COMMUNITY SERVICES DEPARTMENT

Subject: Retreat at TimberRidge Filing No. 2 Final Plat, Review #2 (SF-21-021)

The Park Operations Division of the Community Services Department has reviewed the Retreat at TimberRidge Filing No. 2 Final Plat, Review #2, and has the following additional comments of behalf of El Paso County Parks. Updated recommendations are shown below in highlighted bold.

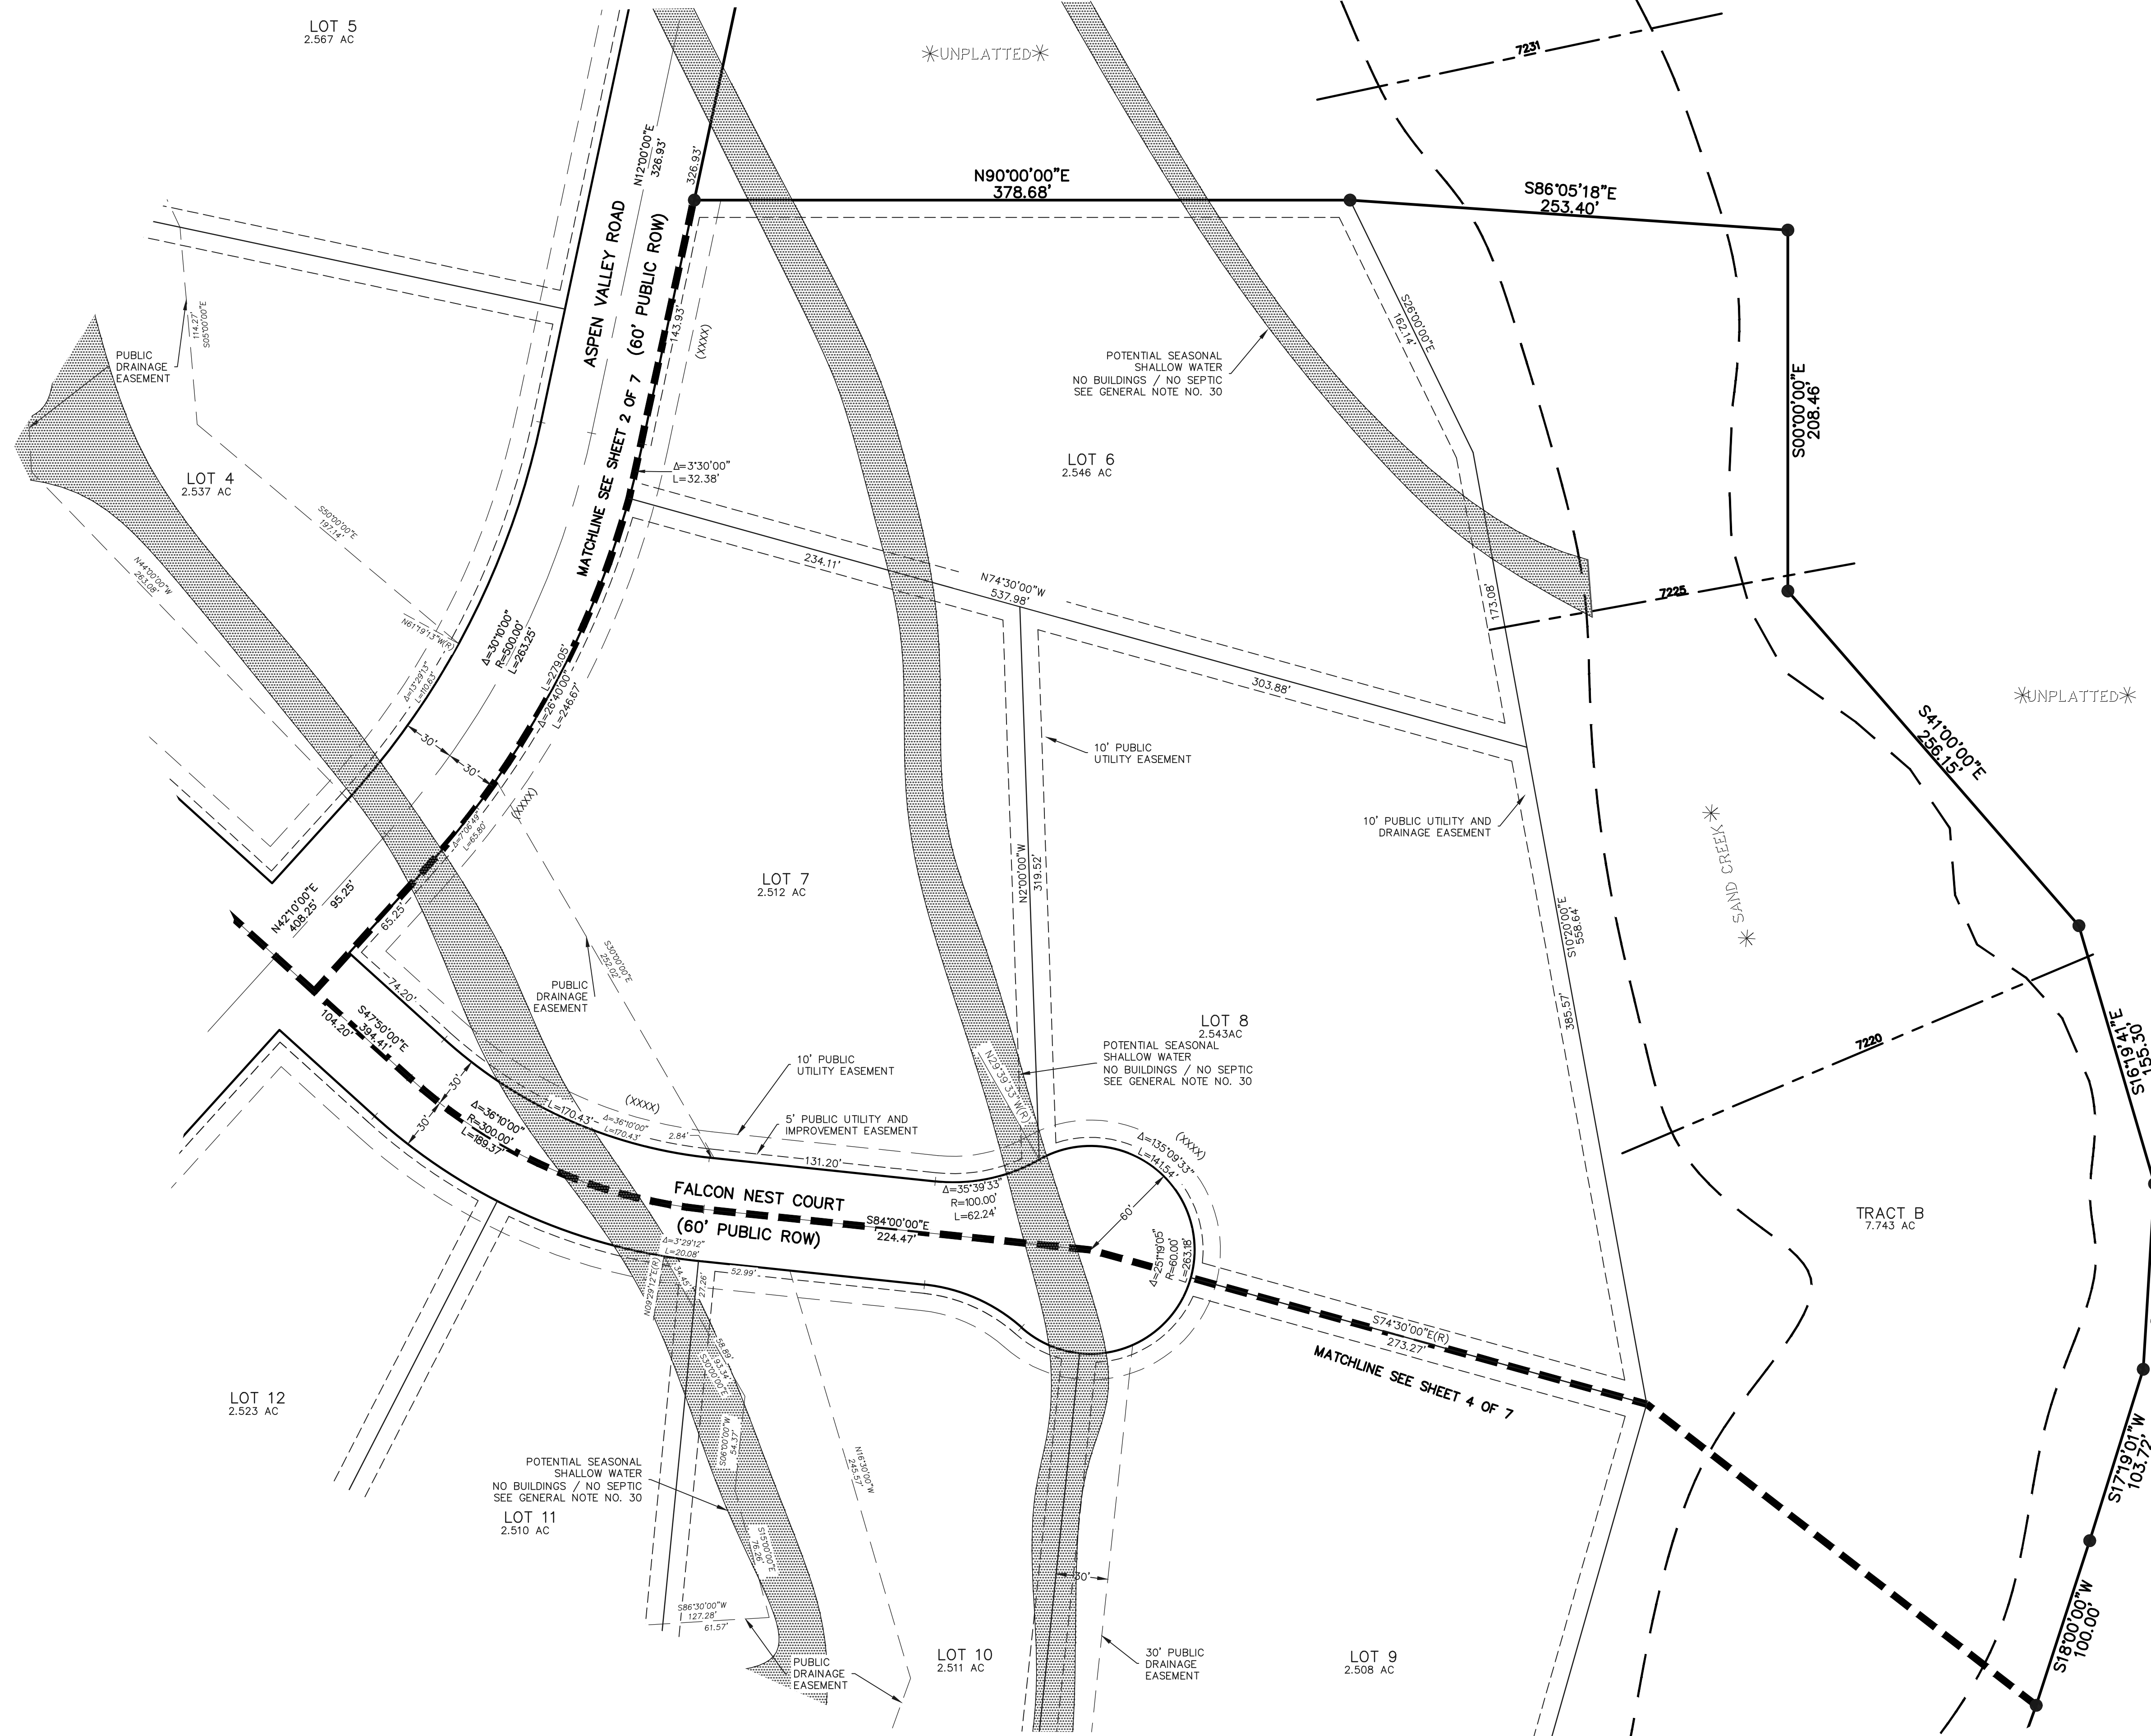
Due to the inclusion of Tract A within the Tract B and the overall Sand Creek drainage corridor, the applicant shows the proposed regional trail within Tract A, thus necessitating the need for a trail easement dedication to El Paso County. Furthermore, the following recommendation was submitted when El Paso County Parks reviewed the second submittal of The Retreat at TimberRidge Filing No. 1 Final Plat in October 2019:

In conclusion and due in part to the changing nature of the aforementioned tracts, staff recommends that the applicant dedicate to El Paso County Parks a 25-foot trail easement through the Retreat at TimberRidge Filing No. 1 Final Plat, Tracts A and B, for the construction, maintenance, and public access of the Sand Creek Primary Regional Trail. Until such time that Tract B is accepted by and deeded to El Paso County, this trail easement dedication shall be required. Due to its ownership by the Retreat Metropolitan District, the trail easement within Tract A must remain dedicated to El Paso County in perpetuity. As noted in the original recommended motion below, fees in lieu of land dedication for regional park purposes in the amount of \$41,400 and urban park fees in the amount of \$26,100 will be required upon recording of this Final Plat.
